From: [Rachael Stevie \(CD\)](#)
To: "[ljackson@encompasses.net](#)"; "[Ginger Weiser](#)"
Cc: [Holly Erdman](#)
Subject: BL-21-00016 Dahlquist - Request for Information
Date: Tuesday, July 13, 2021 12:30:00 PM
Attachments: [image001.png](#)

From: Holly Erdman <Holly.erdman@co.kittitas.wa.us>
Sent: Tuesday, July 13, 2021 11:58 AM
To: Rachael Stevie (CD) <rachael.stevie.cd@co.kittitas.wa.us>
Cc: Jesse Cox <jesse.cox@co.kittitas.wa.us>
Subject: RE: BL-21-00016 Dahlquist - Notice of Application

Please review the following Boundary Line Adjustment application: BL-21-00016. Any comments need to be submitted by **5pm on July 22, 2021**. Please let me know if there are any questions.

PRELIMINARY BOUNDARY LINE ADJUSTMENT

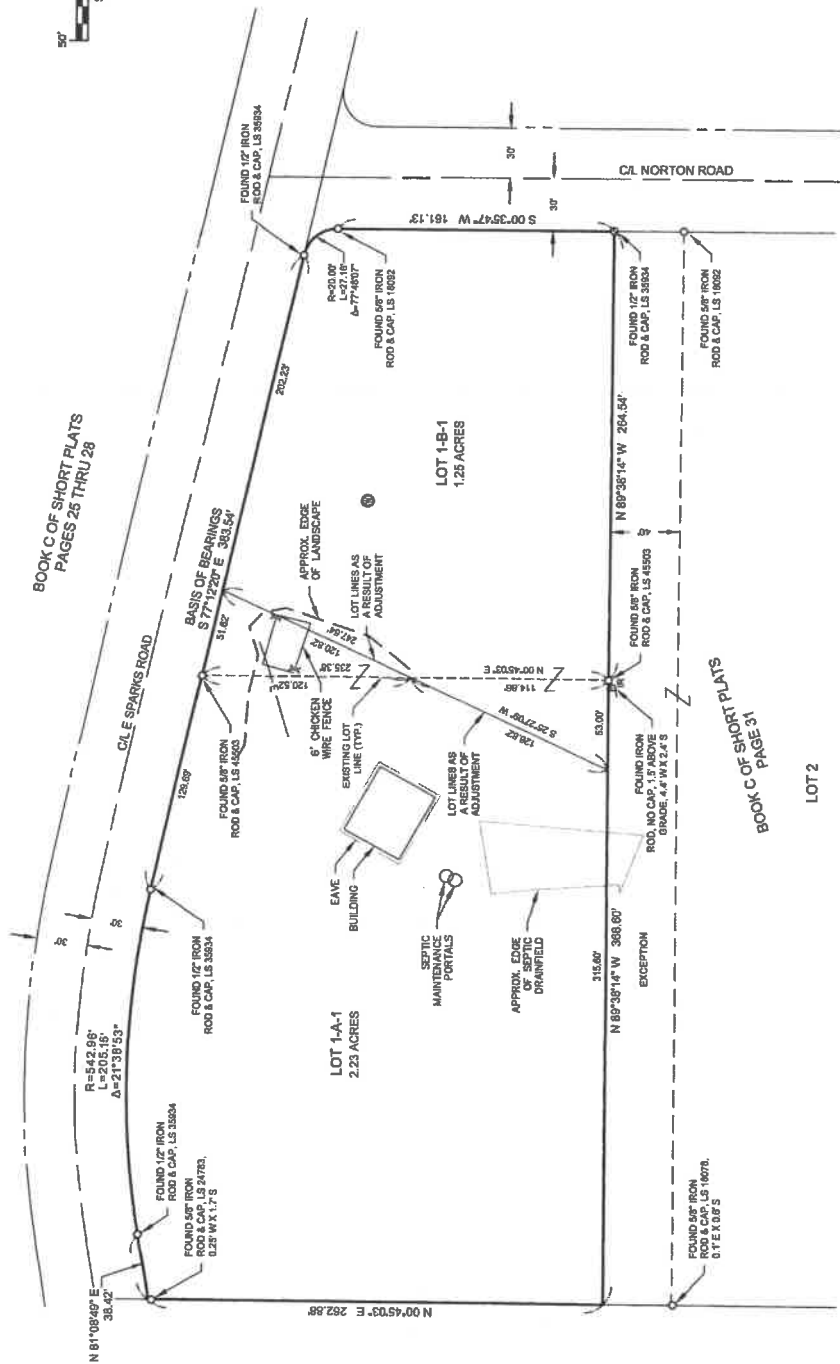
After a quick review of this application, I have a few questions: Where is the well located on Lot 1A-1 and how far from the property lines is it?

What is the distance from the existing drainfield and reserve drainfield to the proposed property line for lot 1A-1?
Is the well the only improvement on Lot 1B-1? If so, how far from the proposed property line is it?
Is the well a shared well between lots 1A-1 and 1B-1, if so, is there a legal shared well agreement?
